PMcL/3167D5/SA1 Response

**NEW ROAD DEVELOPMENT
A259 NEW ROAD, RUSTINGTON,
LITTLEHAMPTON**

S278 HIGHWAY ACCESS WORKS

**Road Safety Audit Designer's Response
STAGE 1**

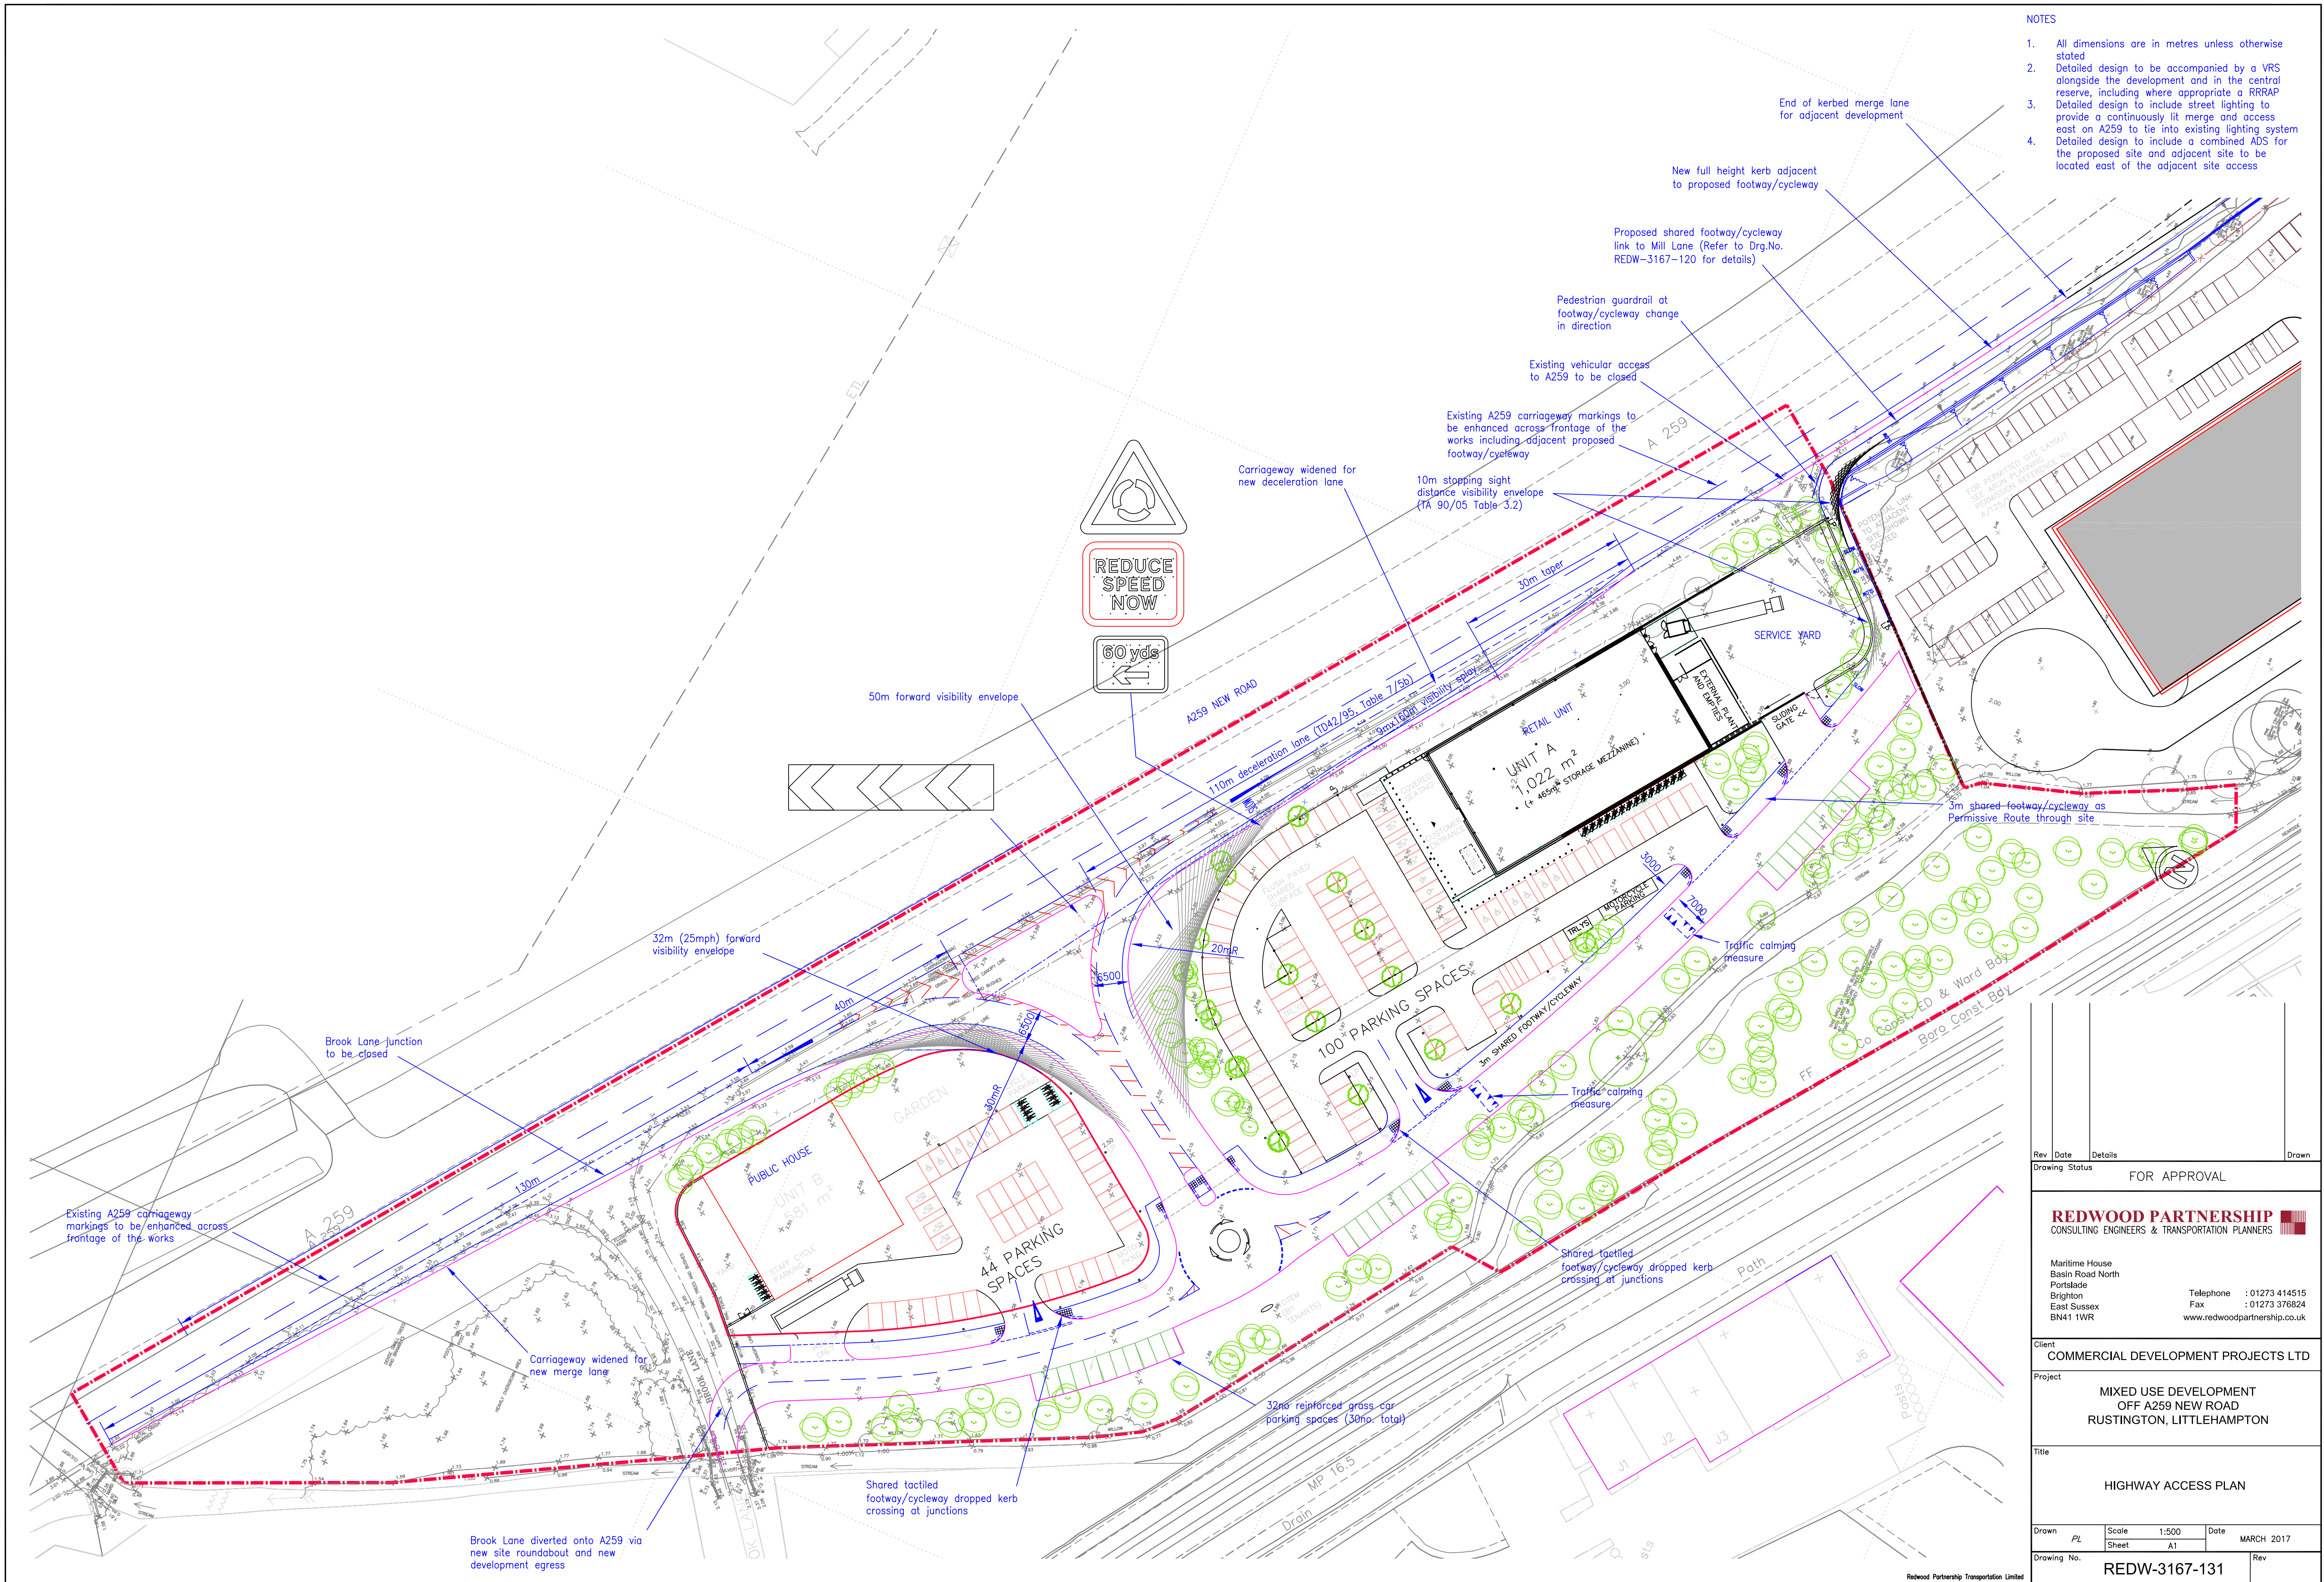
The Cross Sections illustrated on the scheme drawings, identify that a retaining wall and 1 metre rail are to be provided to ensure that NMU's do not fall to the south into the adjacent site,

however no Vehicle Restraints are illustrated. It is noted that Vehicle Restraints are to be provided alongside the development but not alongside the proposed footway / cycleway link.

Recommendation: It is recommended that a Vehicle Restraint System similar to the recently constructed measure, is provided.

Problem - No dropped kerb crossing points

The scheme drawings do not identify any directional road signage and therefore it is possible that vehicles intending to access the proposed retail unit and public house, will manoeuvre as if to access the adjacent recently constructed development and change direction at the last minute when the driver becomes aware of the access to the proposed retail unit. Last minute lane changes could result in vehicle.

The A259 road markings alongside the proposed footway / cycleway appear to be faded. This is an existing issue, however observations show that the recently constructed scheme has re-laid markings adjacent to the works. There will therefore be a gap in the markings which could confuse drivers

Recommendation: It is recommended that the A259 road markings are re-laid alongside the entire scheme.

Problem – No directional signage proposed

The scheme drawings do not identify any directional road signage and therefore it is possible that vehicles intending to access the proposed retail unit and public house, will manoeuvre as if to access the adjacent recently constructed development and change direction at the last minute when the driver becomes aware of the access to the proposed retail unit. Last minute lane changes could result in vehicle.

Recommendation: It is recommended that appropriate signage is installed to inform approaching drivers of the amenities off each access.

RESPONSE: Note 2 on **Drawing No. REDW-3167-131** confirms that the detailed design will be accompanied by a VRS alongside the development and in the central reserve, including where appropriate a RRRAP. **Drawing No. REDW-3167-130-Revision A** now includes a note to this effect and the sections show an indicative safety fence.

RESPONSE: Shared tactile paved pedestrian/cycleway dropped kerb crossings have been added to **Drawing No. REDW-3167-131**.

RESPONSE: A note has been added to **Drawing No. REDW-3167-131** to confirm that existing A259 road markings along frontage of the new highway works shall be refreshed as part of the detailed design.

RESPONSE: A combined advance direction sign (ADS) for both accesses will be included in the detailed design which will identify the presence of 2 accesses and their respective uses. The proposed signage will be located to the east of the adjacent development. Note 4 has been added to **Drawing No. REDW-3167-131**.
